**Re: PA22-042 – Sunnyside Village Co-Housing – Technical Review 1**  
3121 66<sup>th</sup> Ave NE – APN: 29050300402100

**PRELIMINARY SUBDIVISION / CUP COMMENTS**

## SUNNYSIDE VILLAGE

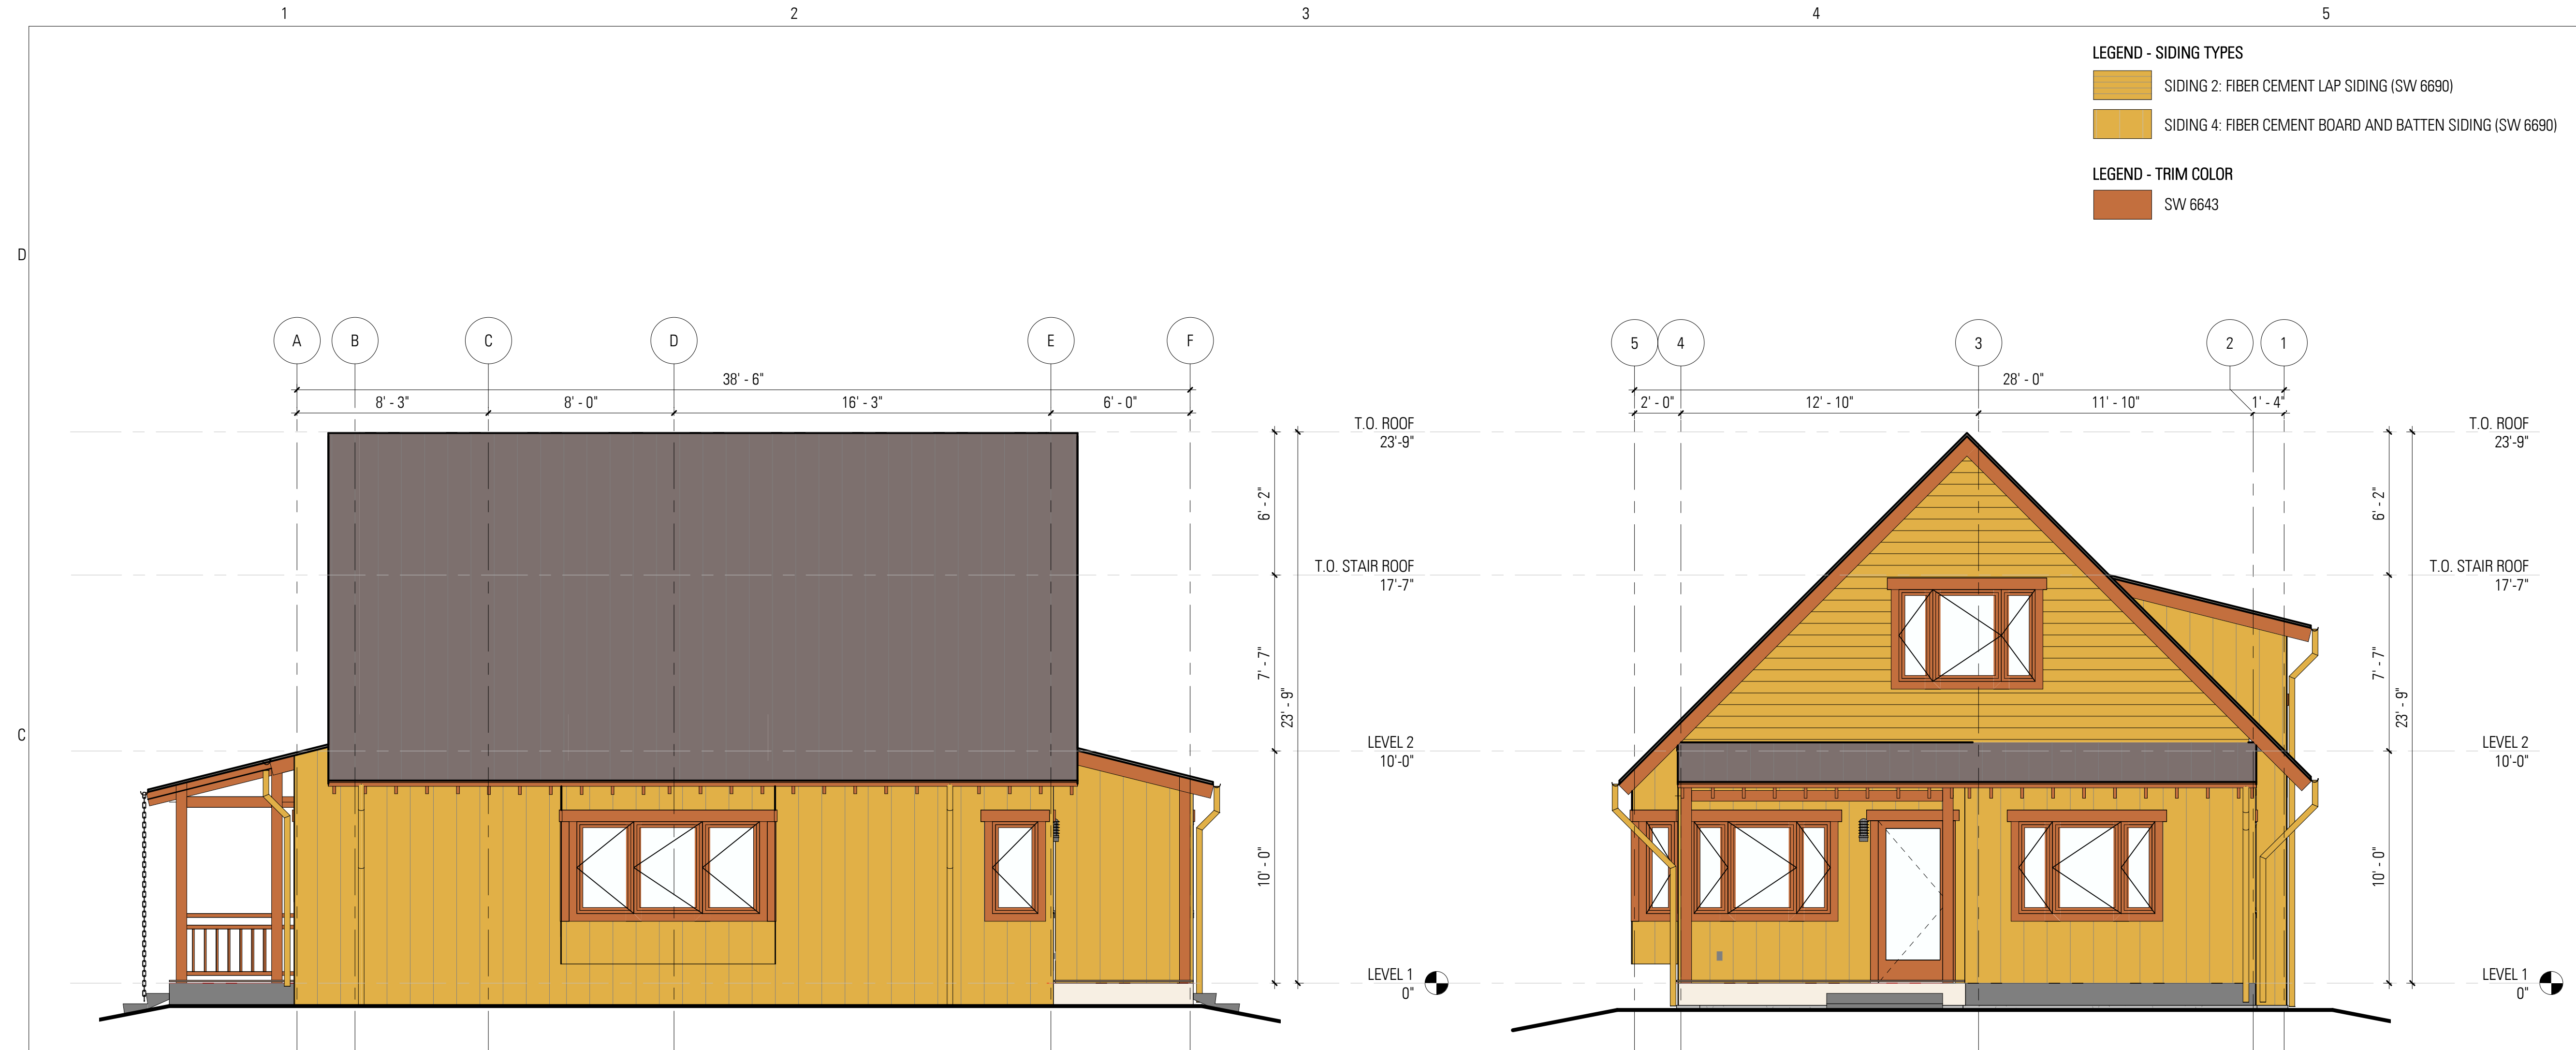
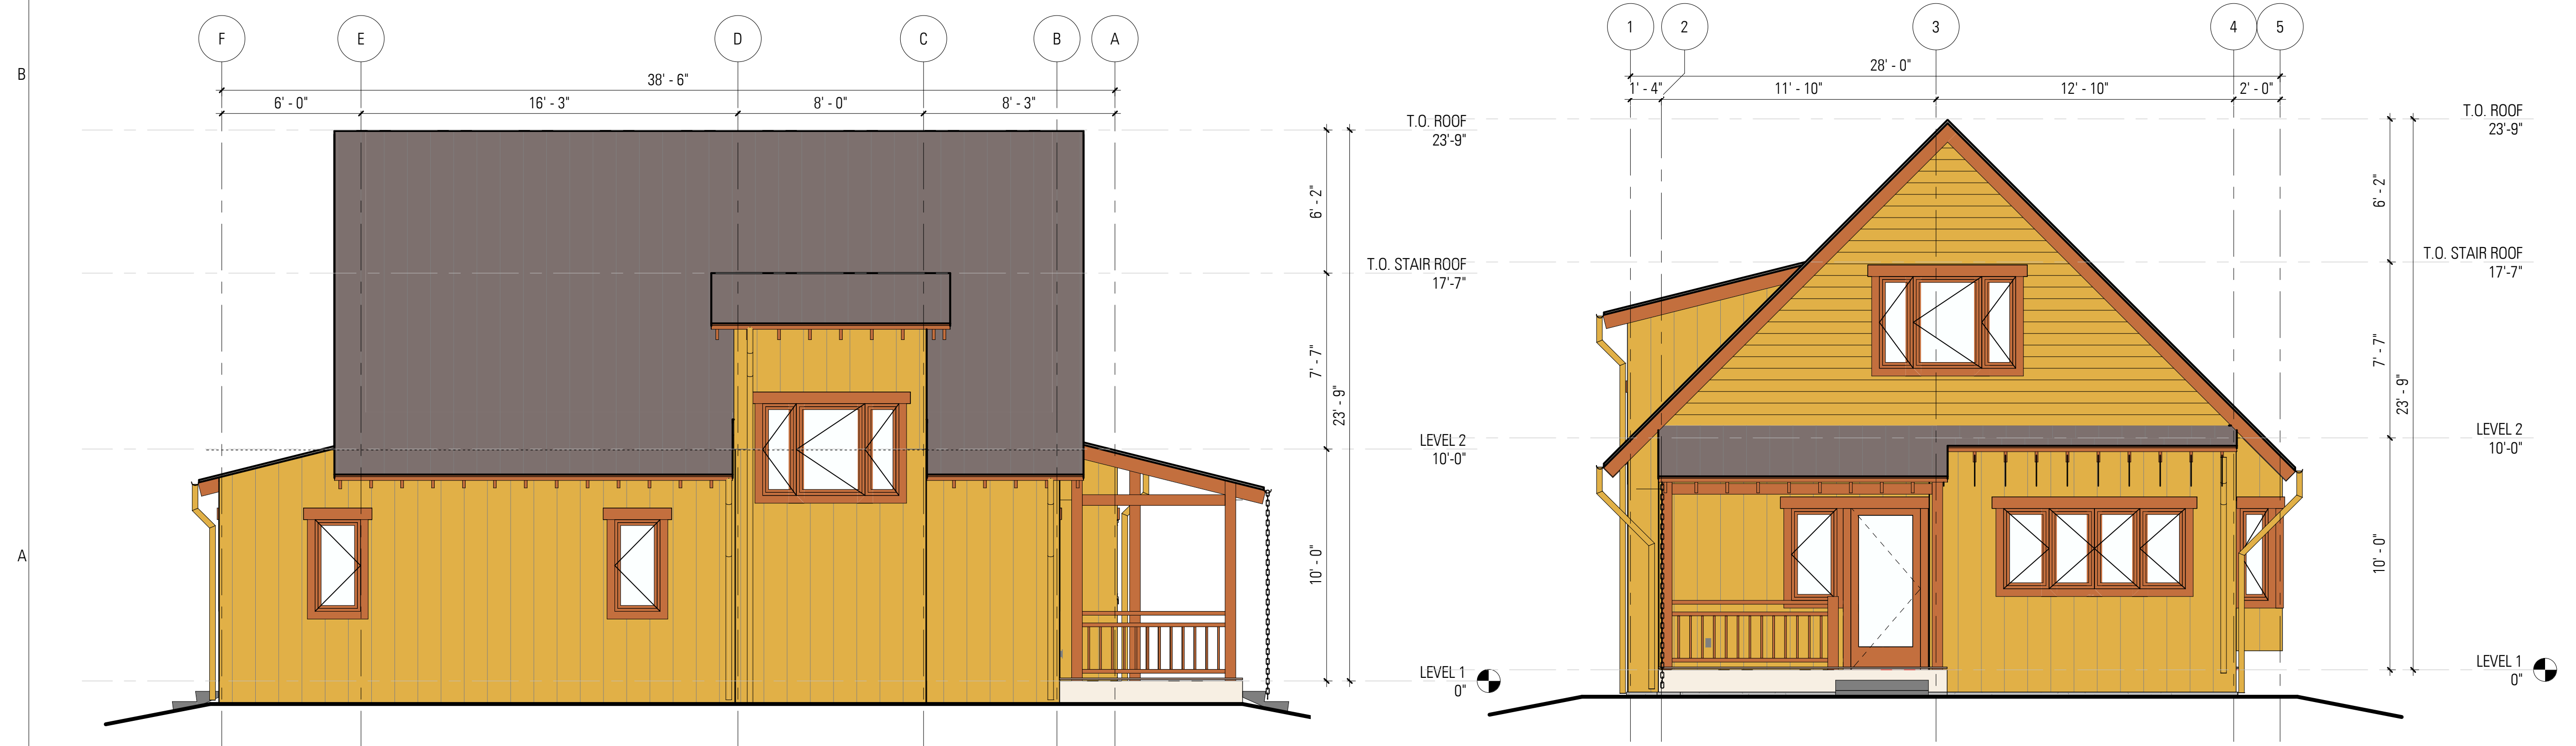
- 9. As proposed, the cottages do not appear to be visually different enough per MMC 22C.010.280(9). Proposed cottage plans A & B and C & D appear to be the same externally, with the exception of color. The cottages must offer a variety of visual interest, such as different roof forms, window design and entries.

PRIVATE ROAD TYPICAL SECTION

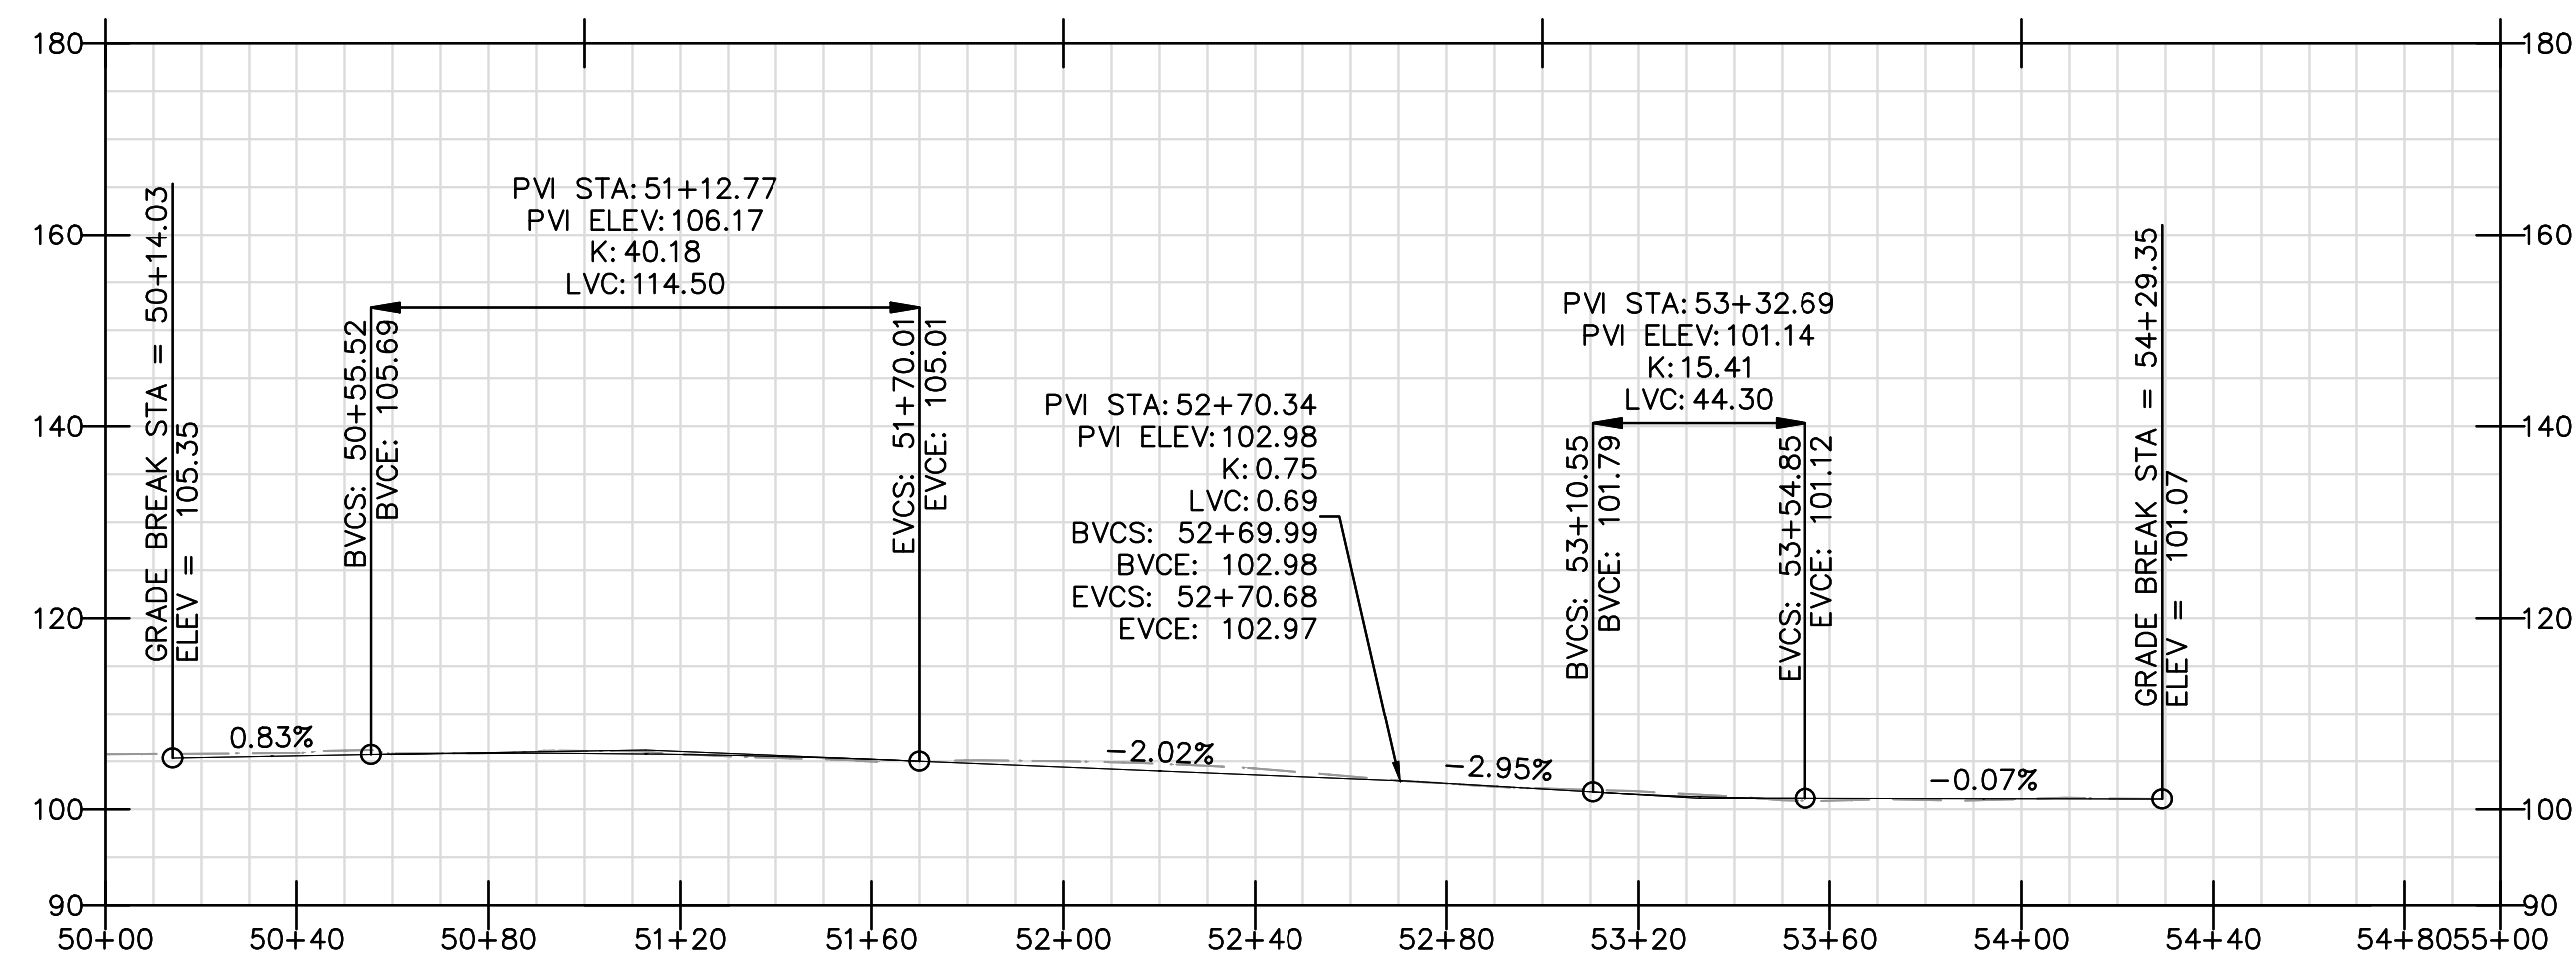
The flush-curb proposal is not consistent with the ADA-ramp configuration depicted at the intersection of 66<sup>th</sup> Ave and the proposed private drive. The proposed flush-curbs will need to be replaced with rolled curbs. Flush curbs in this location would promote pedestrian crossings all along the proposed drive aisle, which the City considers to be a safety hazard. The project proposes ADA-crossing ramps at the intersection of 66<sup>th</sup> Dr and the proposed private drive, which is an acceptable crossing location. The City would also entertain a mid-block crossing east of the Common House if it is provided with a crosswalk, ADA ramps, and pedestrian-crossing signage.

1 SITE PLAN  
1" = 30'-0"

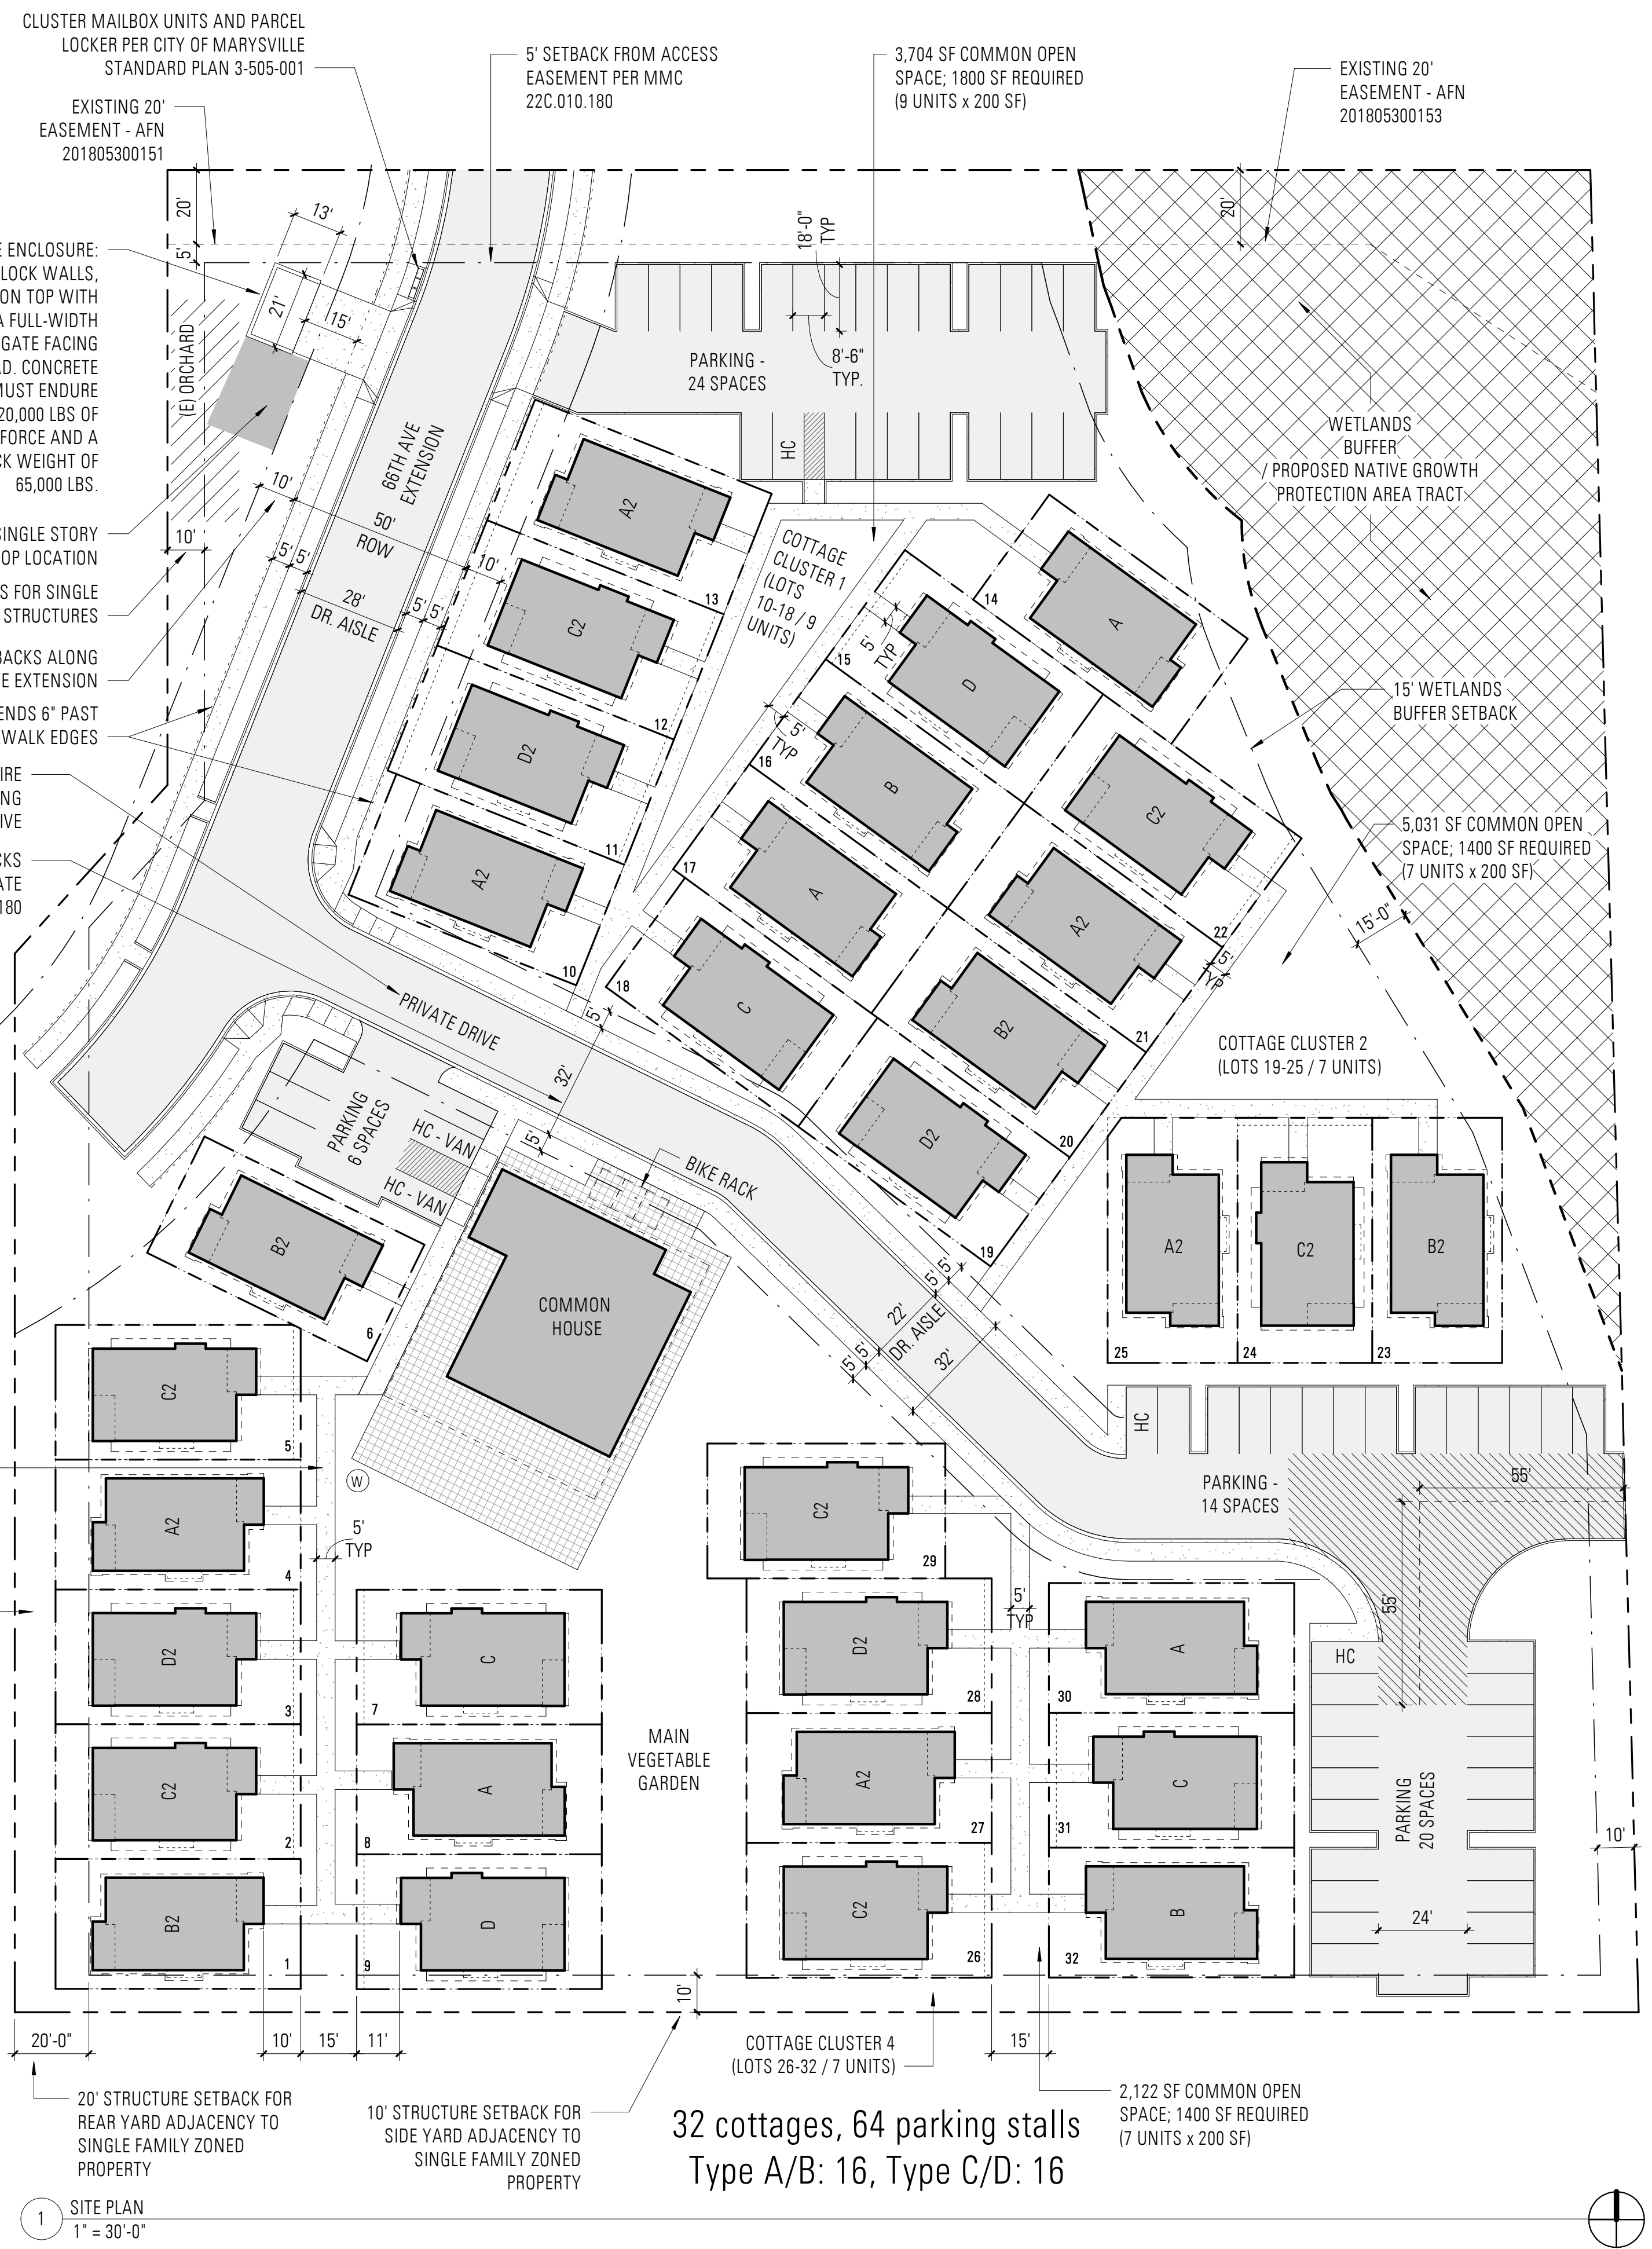
1. Include File Number PA22-042 on all future correspondence, in addition to all site, civil and landscape plans.
2. Amend Site Plan to depict all encumbrances outlined in the provided title report, prepared by Old Republic National Title Insurance Company, dated September 19, 2022. If the encumbrances cannot be depicted they will need to be referenced.

- 8. To better identify the required private and common open spaces, please revise site plan to color code or otherwise delineate the different open space areas.

- 10. The provided site plan shows a well on site—please clarify as to whether the well is to be decommissioned in accordance with Snohomish County Health District standards or if to be retained for irrigation purposes.

14. The onsite wetland and buffer area must be placed in a separate Native Growth Protection Area (NGPA) tract. Please revise site plan to label accordingly.
